11 November 2016

OBJECTION: State Significant Development Application No. 15_7349 - Revesby Resource Recycling Facility, 37-51 and 57-67 Violet Street, Revesby.

Figure 5: Noise Logger Locations

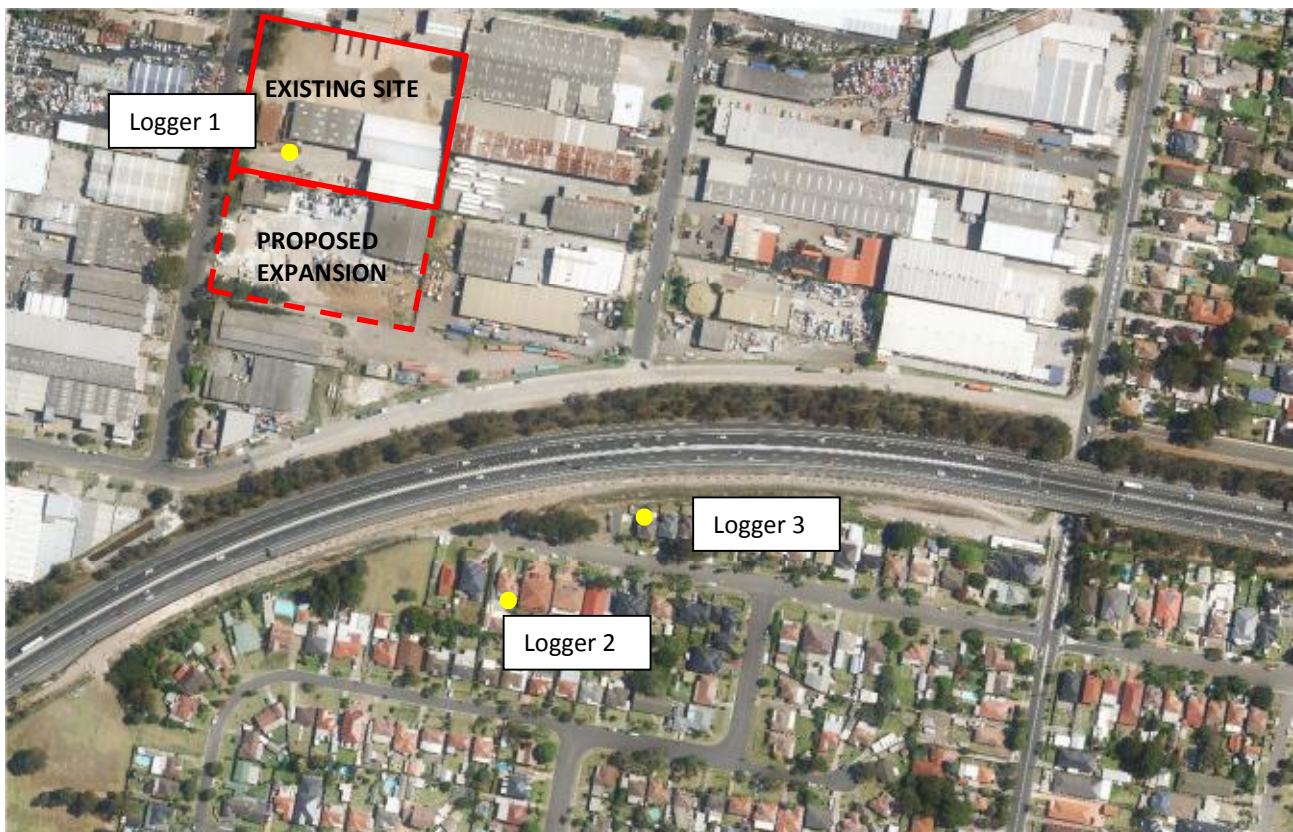
It is proposed that the location of Logger 1 within the EIS noise assessment (EIS Appendix D) did not truly represent the level of noise being omitted from current site operations. Truck movements in and off site would have been assessed (as stated within EIS Table 5-8), however loud operational noises which are focussed within the northern section of the site

(adjacent to the northern boundary which borders 35 Violet Street) would not have been appropriately assessed.

- neighbouring businesses adjacent to this boundary were not considered as sensitive receptors within the noise study even though current operational noises have adversely impacted these neighbours.

Figure 20: Scenario (5) - Predicted Noise Impact – Proposed Operations with No Mitigation Compared to Industrial Criteria – (70 dB(A) (LAeq))

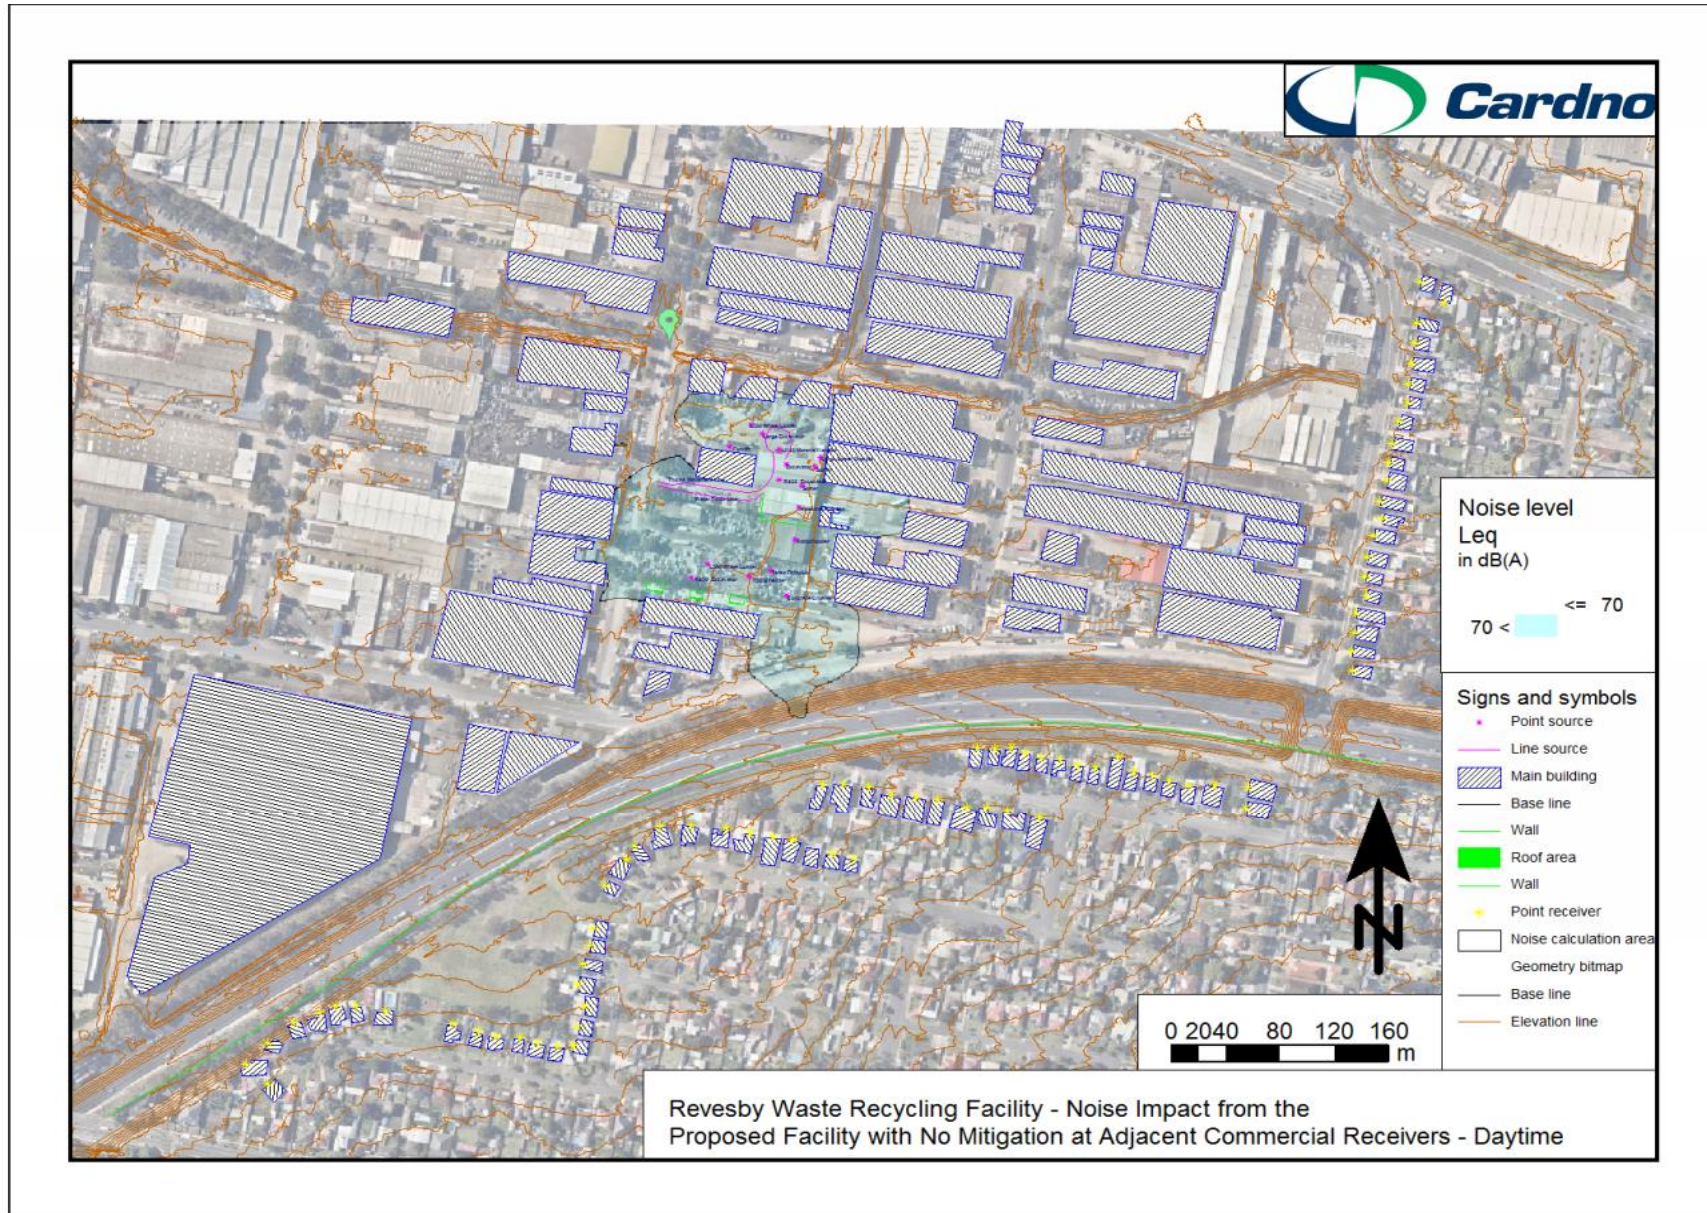
EIS Section 5.4.3.2 indicates that noise levels have also been assessed to each boundary of the site which are currently bounded by industrial and commercial receivers. The conclusion was reached that 'the current site EPA licence and INP industrial criteria of 70 dB(A) was predicted to be exceeded at all of the site boundaries for worst case operation, near to the site boundaries'.

- due to noise levels already being measured at significant levels above 70dB(A) at the neighbouring property, it is not considered that this criteria will only be exceeded during 'worst case' scenarios; and
- the increase of truck movements and the increased number of plant to be used on site under the proposed increased operations will most likely significantly increase noise levels at the site boundaries during normal operations.

Figure 5.4: Measured 24-hour average PM_{10} concentrations at Chullora (2010-2016)

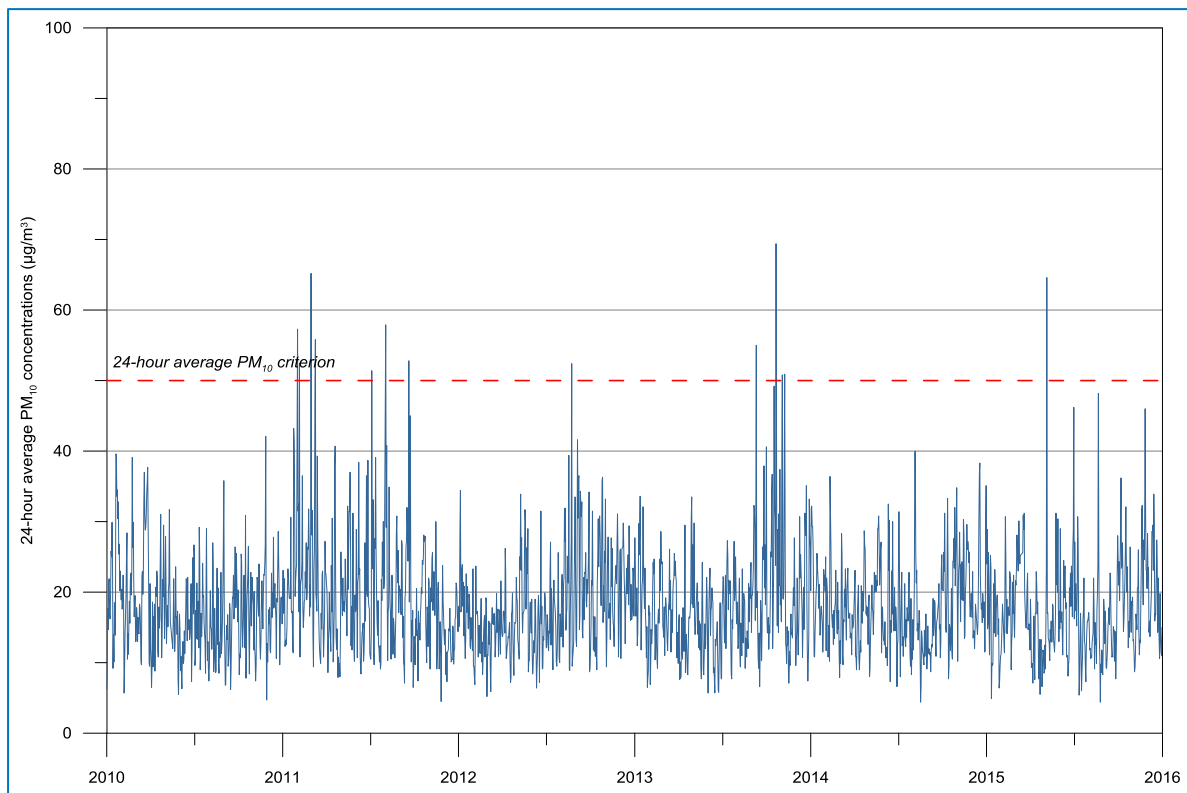
- no site specific monitoring and measurements were taken;
- the measurements adapted for modelling purposes came from a site over 6km from the development site, in an area where it is unlikely that significant dust generation would occur and unlikely to be impacted by dust generation from the development site;
- no data was available for TSP concentrations or dust deposition levels from the adopted data source; and
- the assessment is focused on the nearest residential properties as the most sensitive receptors and does not take into consideration the neighbouring properties and the operations these neighbours conduct (i.e. laser cutting, electronics, spray painting, manufacturing, etc.).
